Consultation Response from KC, Highways Development Management
2025/91184 land off, Bretton Street, Savile Town, Dewsbury, WF12 9BZ
REVISED AND ADDITIONAL INFORMATION RECEIVED: Erection of two storey industrial unit (Use Class E(g)(iii)), with associated car park, service area and other associated works
Date Responded: 14 th July 2026
Responding Officer: C Dows
Responding Ref: K15-5SW/2

Recommendation: Further information required

Transport Technical Note 65905 Issue 1, Dated 12th May 2026

Drainage Strategy

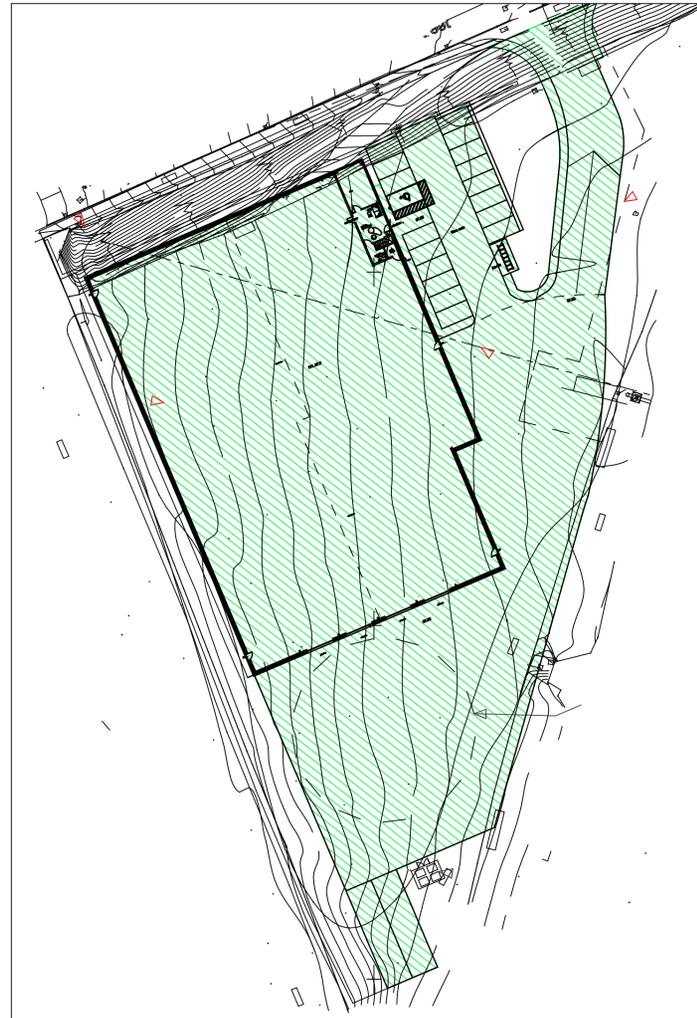
Further Information Required: It is noted that based on Drawing No. KS826/D01 Rev. P2 – Drainage Strategy, in the vicinity of the proposed site access there appears to be a level difference between Bretton Street and the internal site level of around 2.5m, with the site being 2.5m lower than Bretton Street. To ensure a suitable vertical alignment can be achieved a long section of the access road should be provided. Pedestrian access is provided via a footway along the western edge of the access road, the gradient of the footway needs to be considered to ensure the access is suitable for all likely users. It is observed that upon entering the site the footway reduces from 2m to approximately 1.5m wide, footway should be retained at 2m wide – amend accordingly.
